3/2011/0465

**Subject:** FW: 11015 Stonebridge Mill, Preston Road, Longridge

**Subject:** RE: 11015 Stonebridge Mill, Preston Road, Longridge

Drawing Name:
PROPOSED PLANS

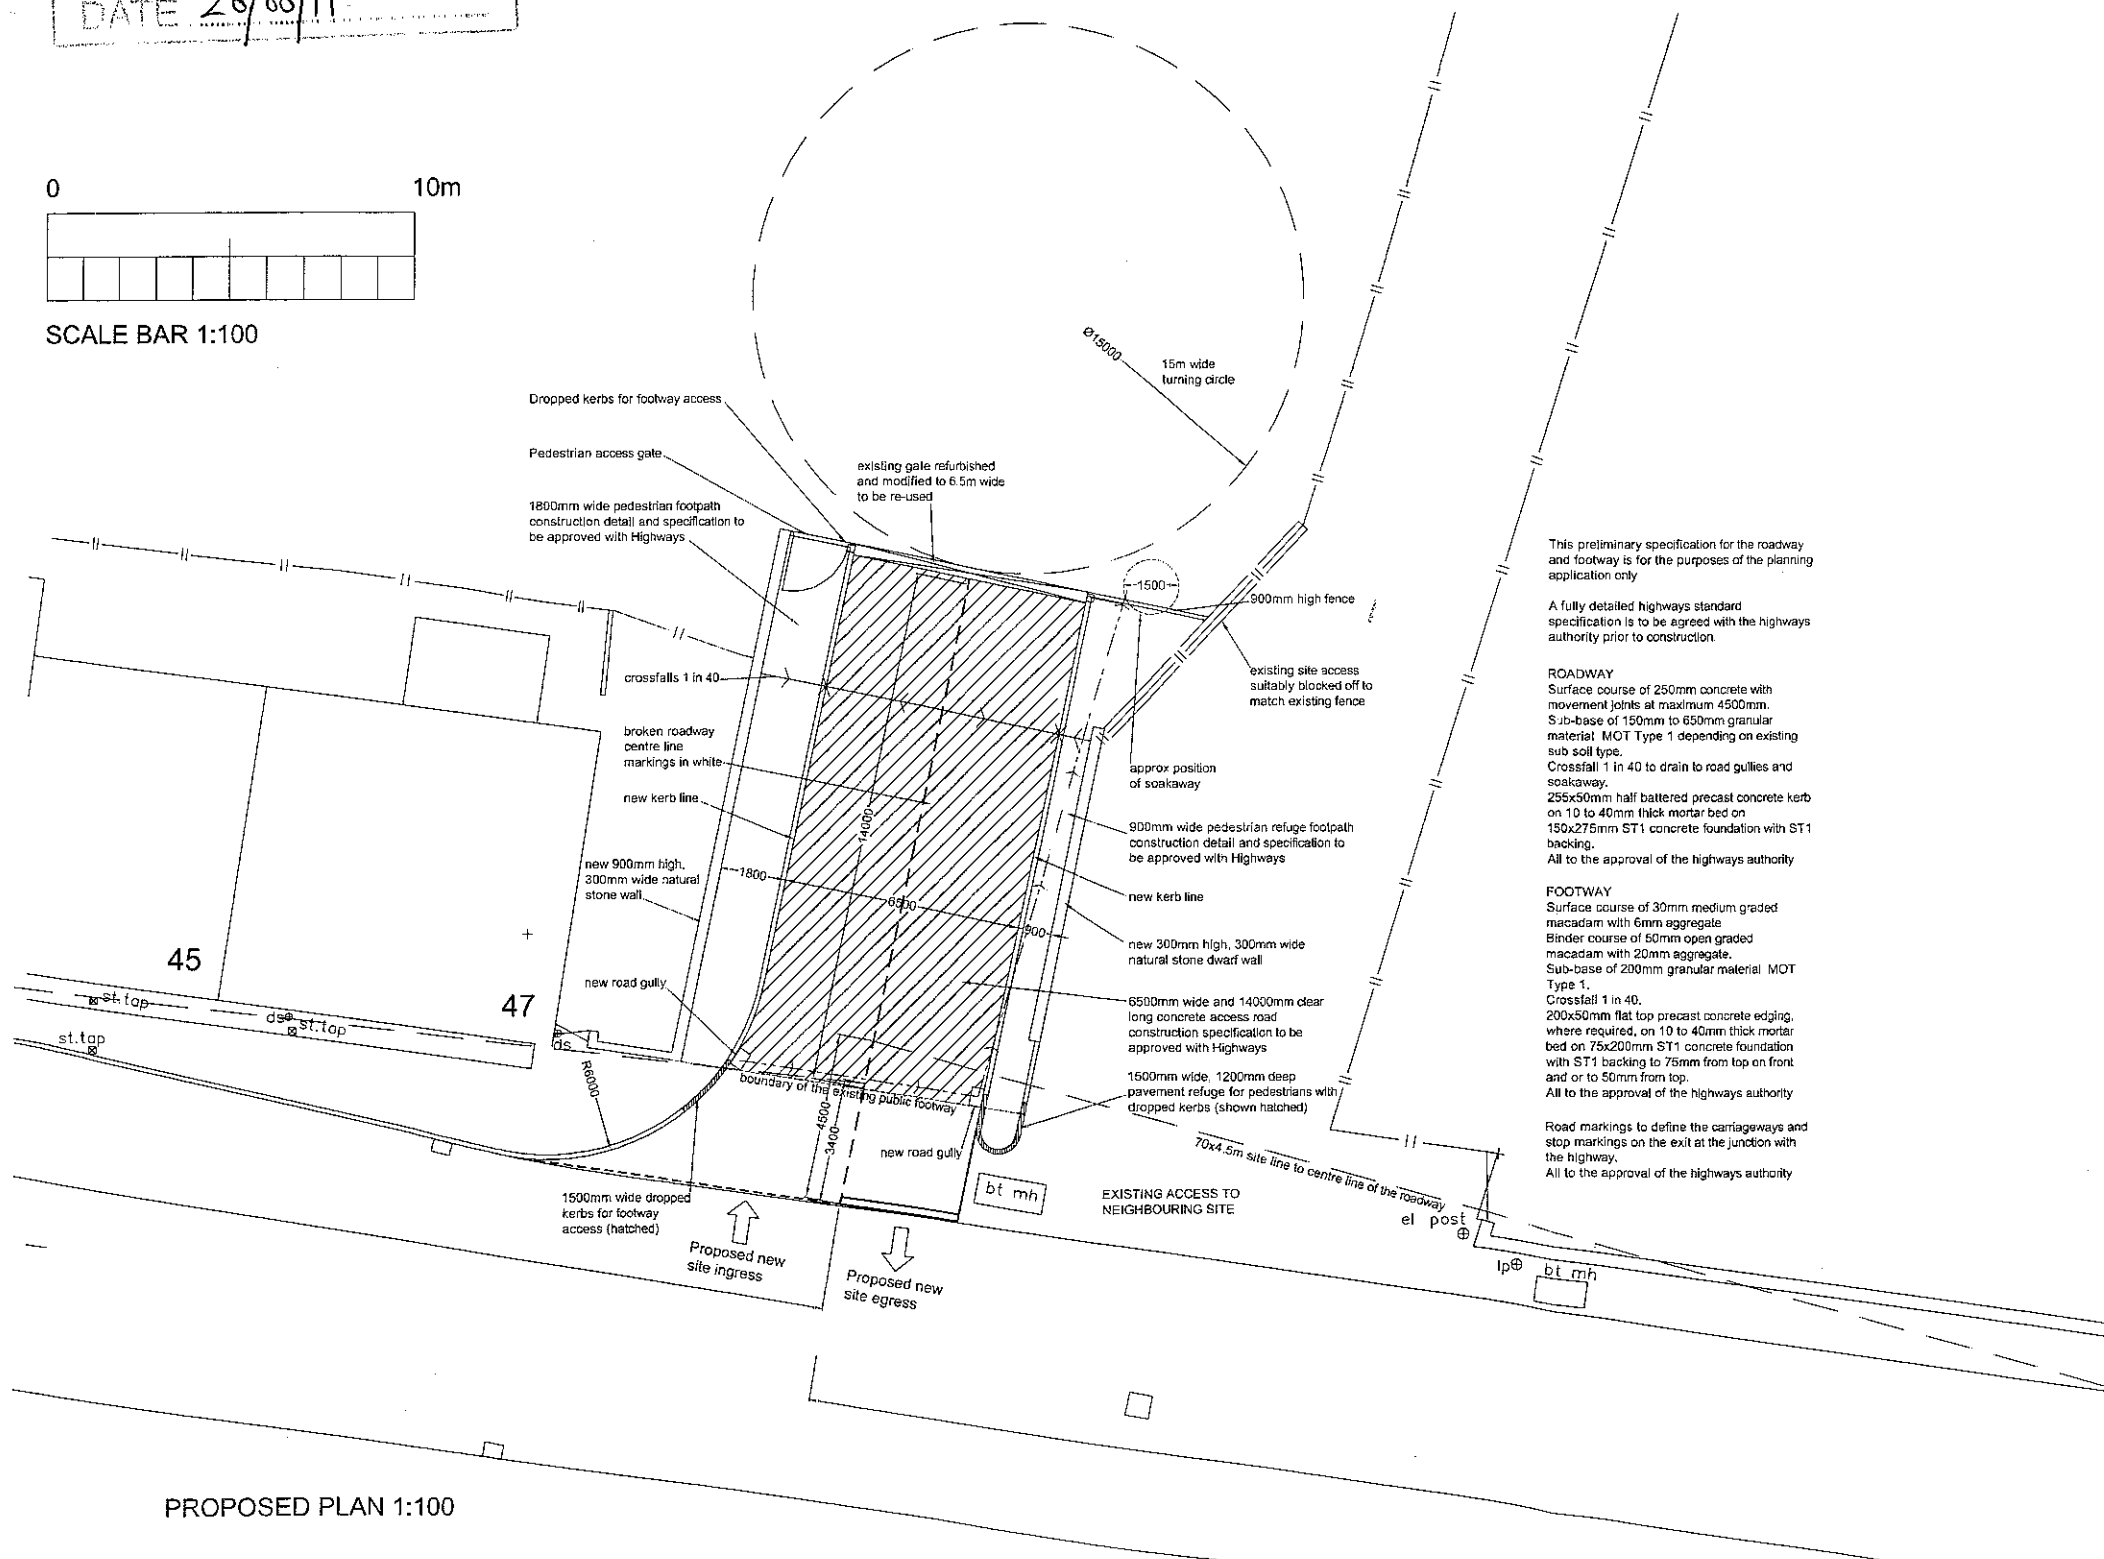
Whilst the proposed arrangements are not ideal, the latest version of the plan represents the best that can be achieved at this location.
